Code & Life Safety Review Notes

Occupancy Classification: Assembly (A-2)

LIFE SAFETY PLAN

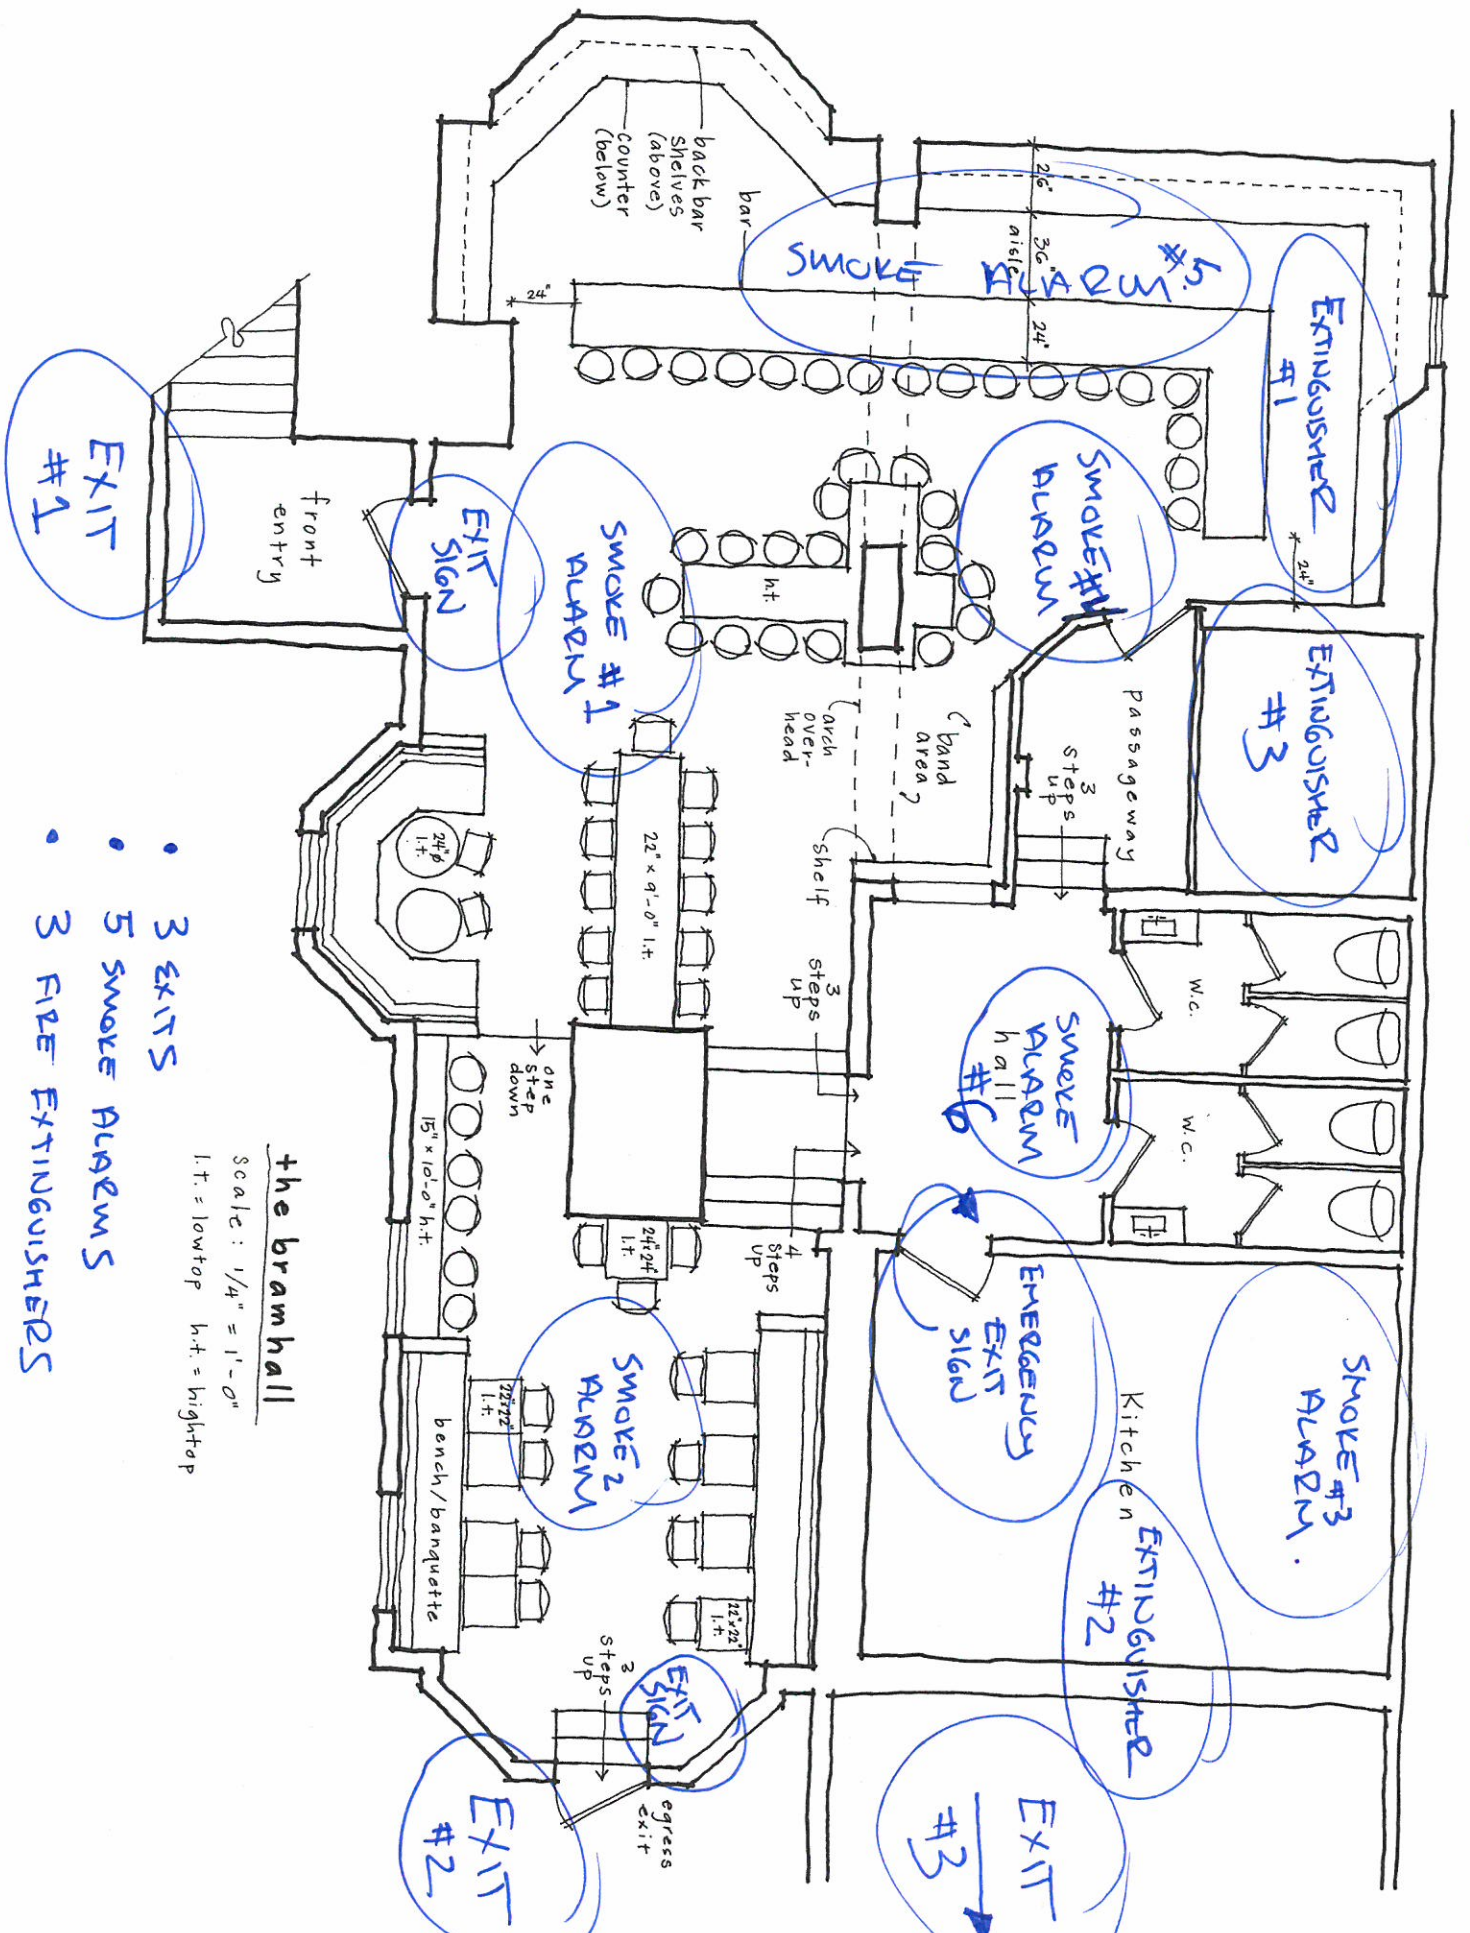
Occupant Load: 15 square feet (net) per person with moveable tables & seating= 64 Occupants

Fire Alarms & Signaling: per NFPA 72

Handrails: Provide handrails as noted on plan, per NFPA 101, Section 7.2.2.4

Sheet Title: SECOND (STREET) FLOOR PLAN

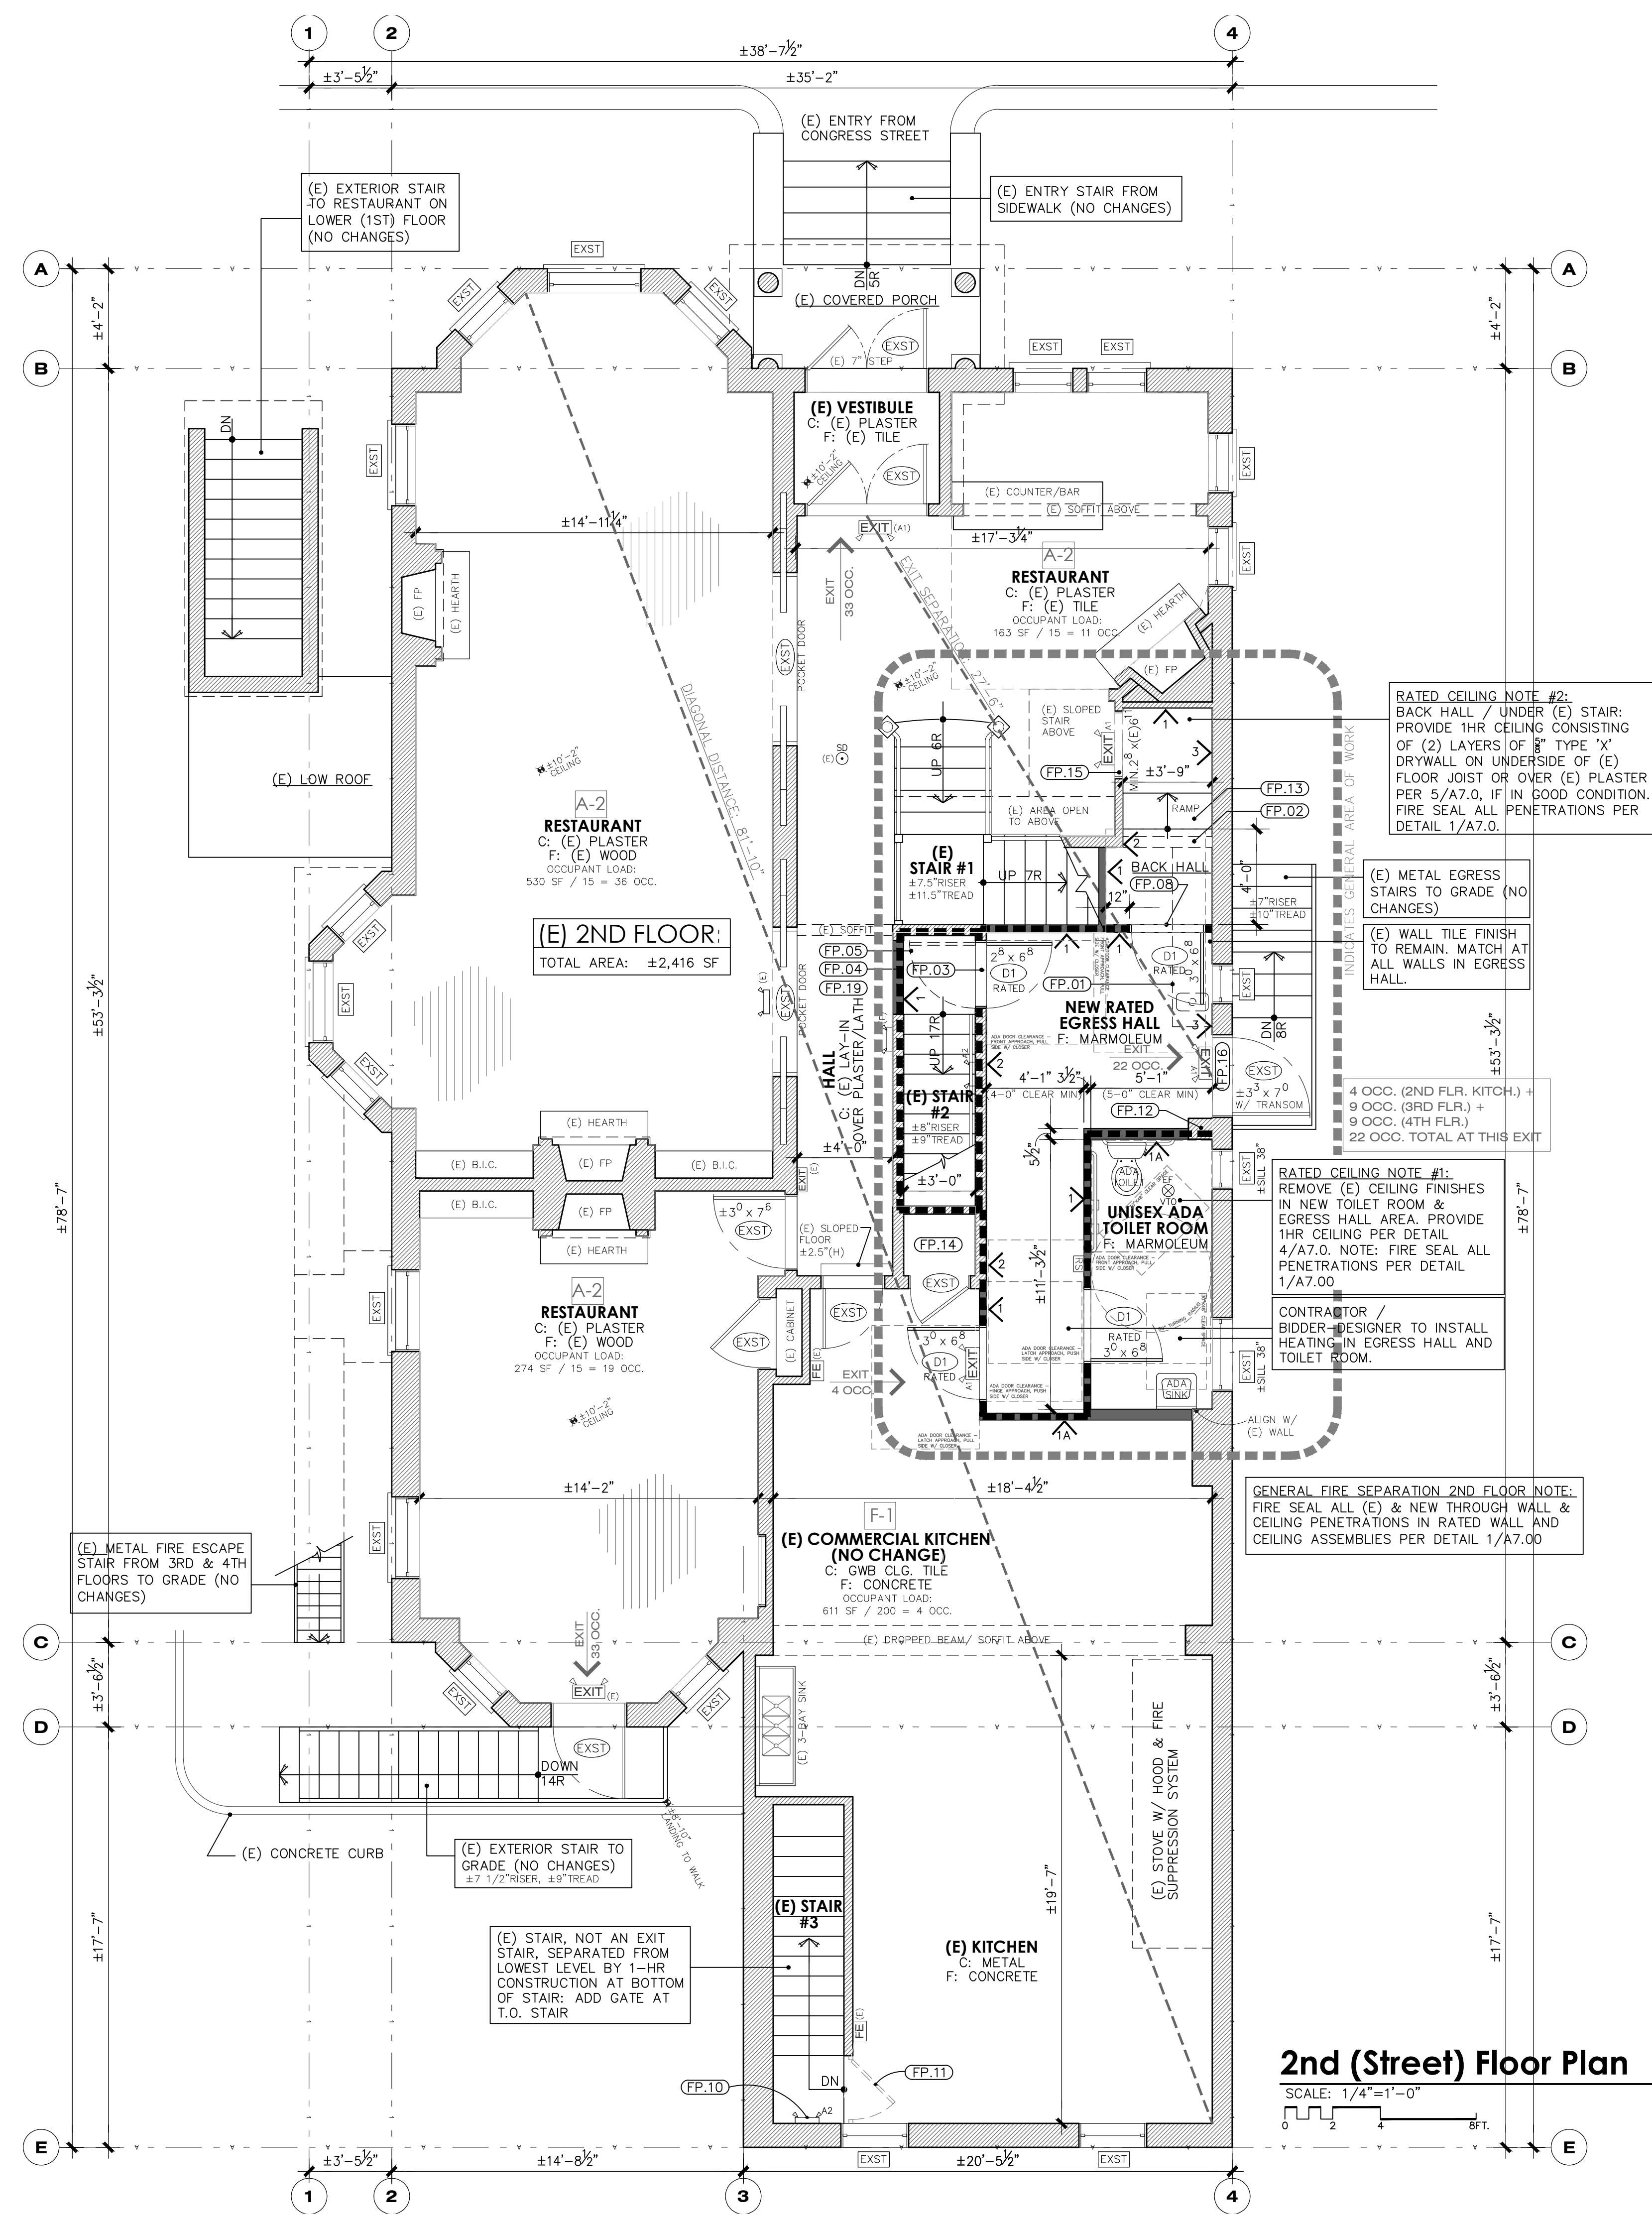
Remoteness of exits: 1/3 the minimum diagonal of the room w/ sprinklers

- 1-hour fire separation between basement and first floor w/ sprinklers
- 1-hour fire separation between enclosed Rear Staircase and basement level
- 1-hour fire separation between enclosed Mechanical Room and basement level
- Kitchen does not need to be separated from the Dining/Serving area
- Kitchen does not need to be separated from the Storage Group S-2 when sprinklered, per IRC 508.4
